PR-2022-006568

SD-2023-00147 - REHEARING OF PRELIMINARY PLAT

Project Name: 9200 Wilshire Subdivision

Rehearing of Preliminary Plat – to focus on Retaining and Privacy Walls

CITY OF ALBUQUERQUE
PUBLIC WORKS DEPARTMENT
ENGINEERING DEVELOPMENT GROUP
WILSHIRE PLACE SUBDIVISION
GRADING AND DRAINAGE
GRADING PLAN

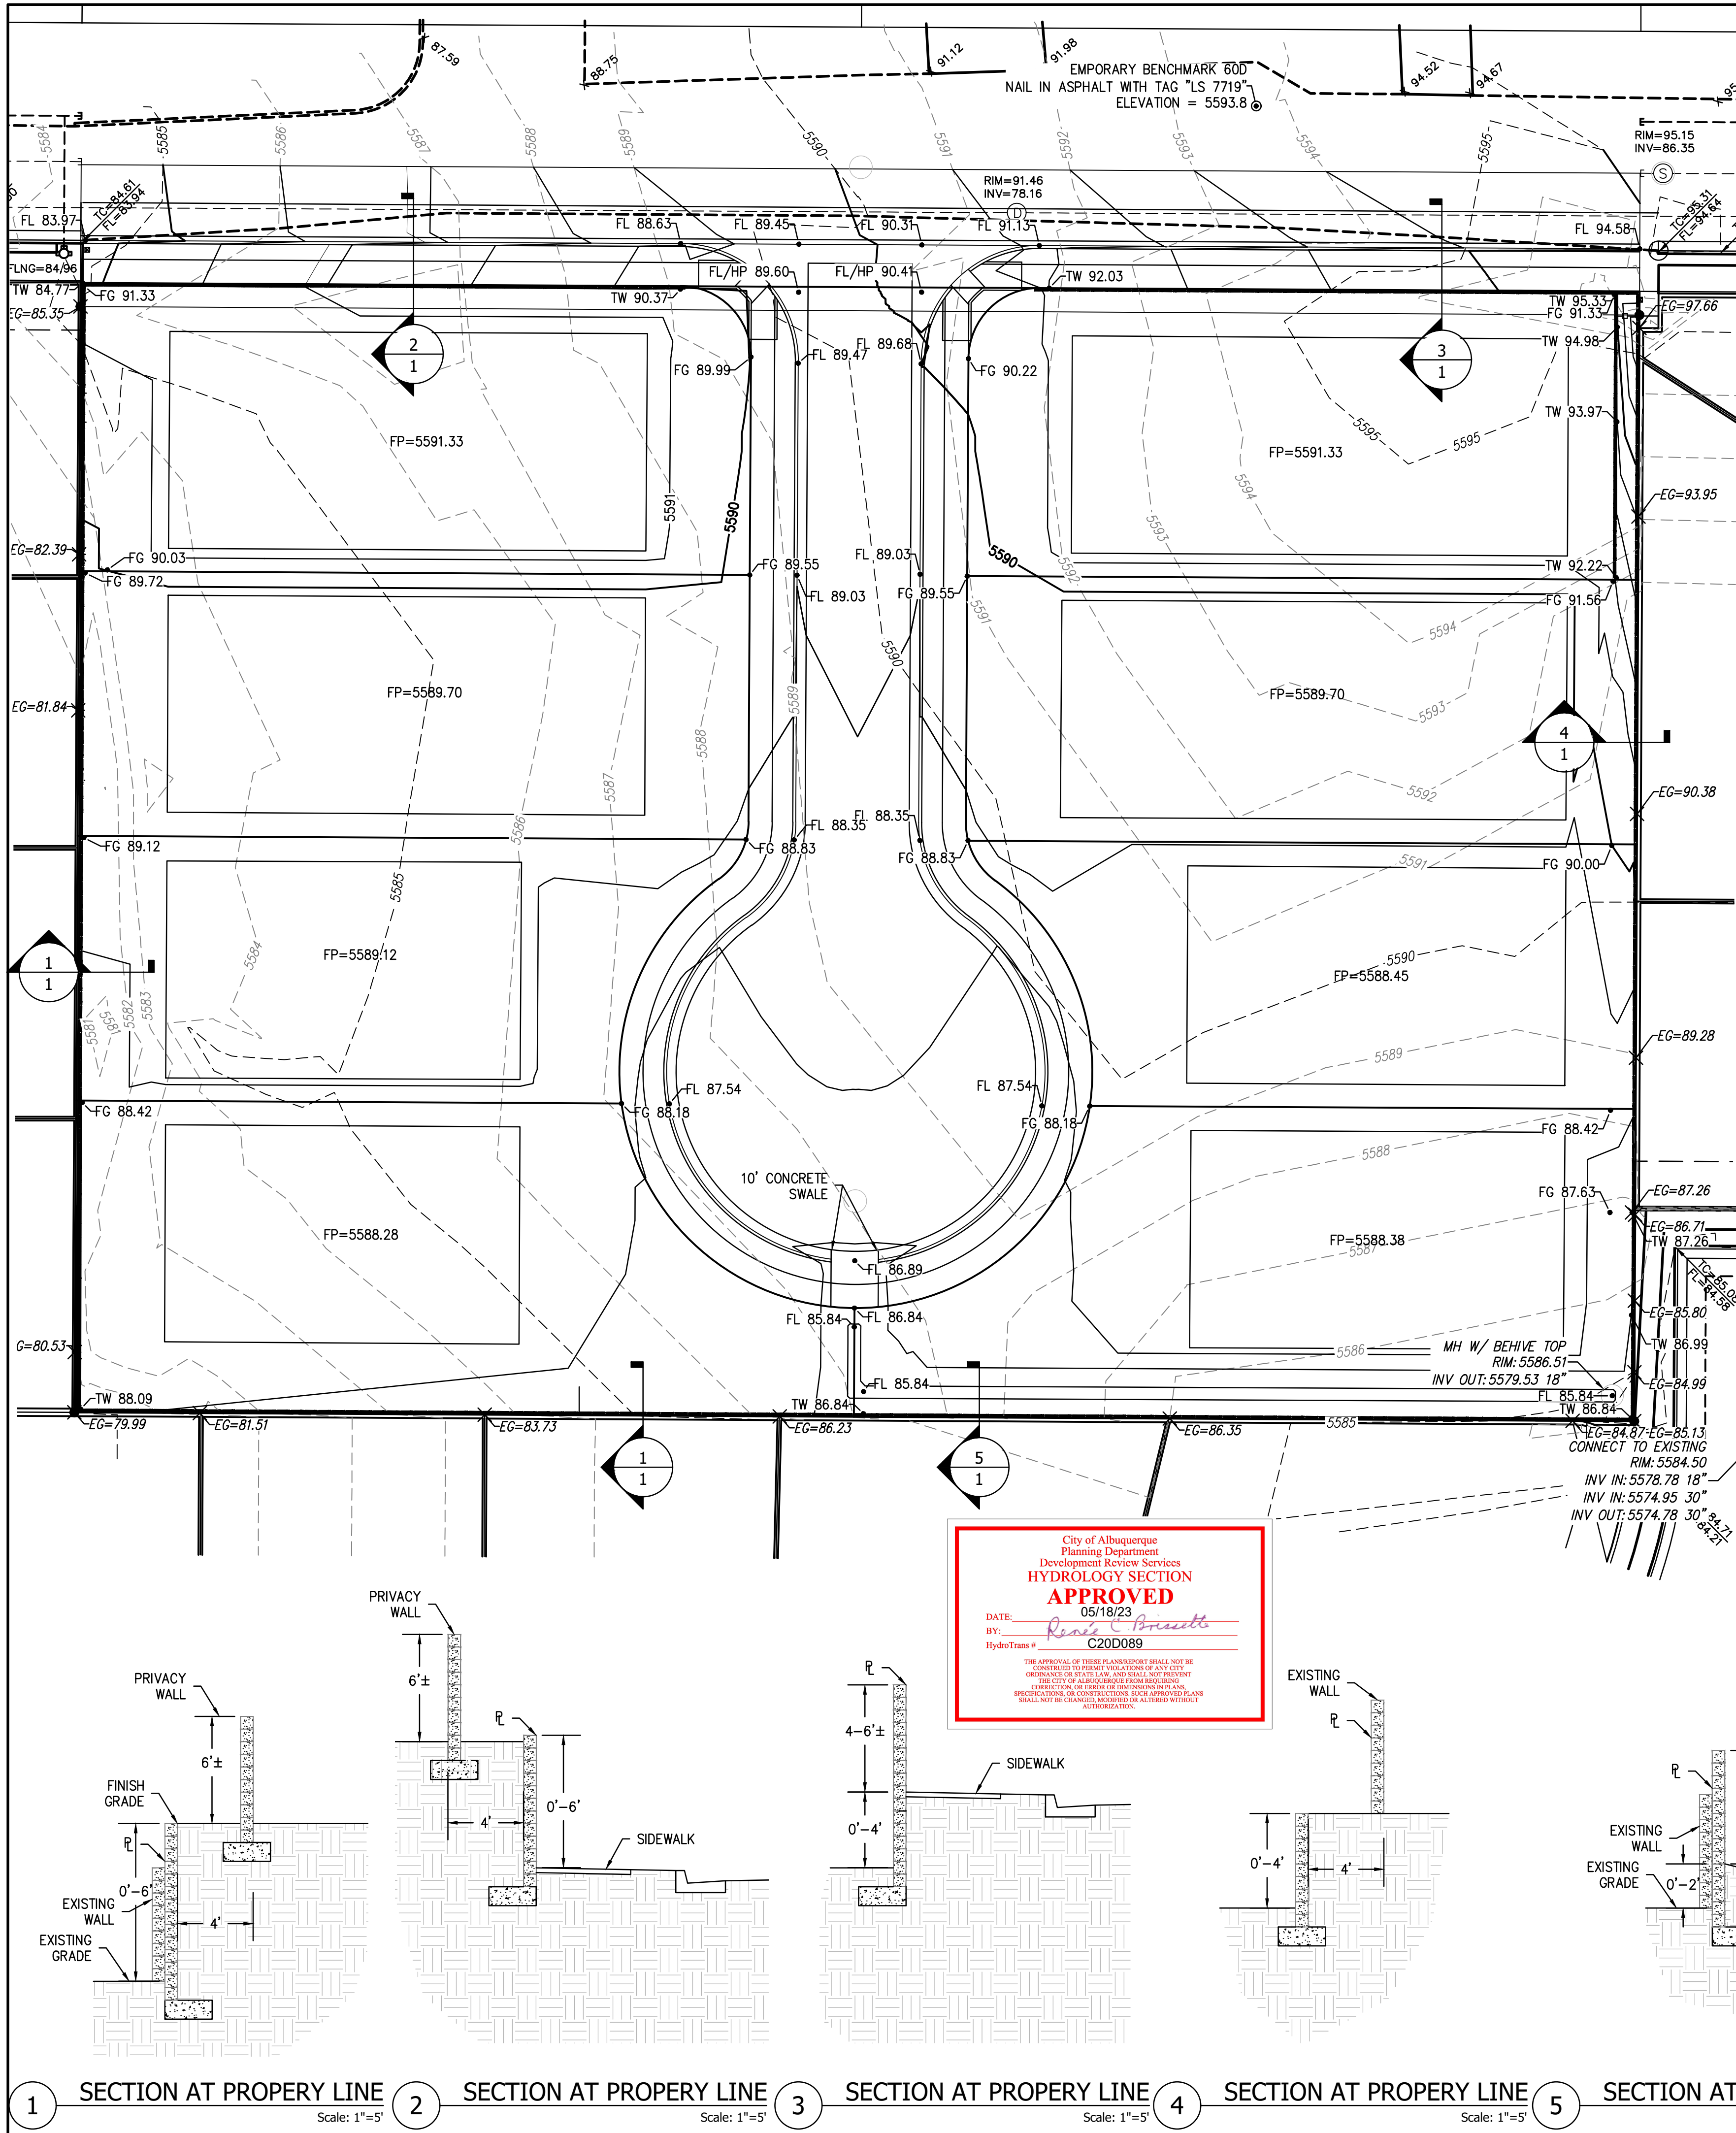
- The subdivision grading plan with height of fill remains out of compliance with IDO 5-4(J)(1)(b) below.

5-4(J)(1)(b) New subdivisions shall blend development into the adjacent environment with a minimum of grade change. Extensive fill that raises the grade for proposed lots at the edge of a proposed subdivision above the grade of nearby property shall be avoided. Significant cuts near the edges of a proposed subdivision to lower the grade within the development shall be avoided.
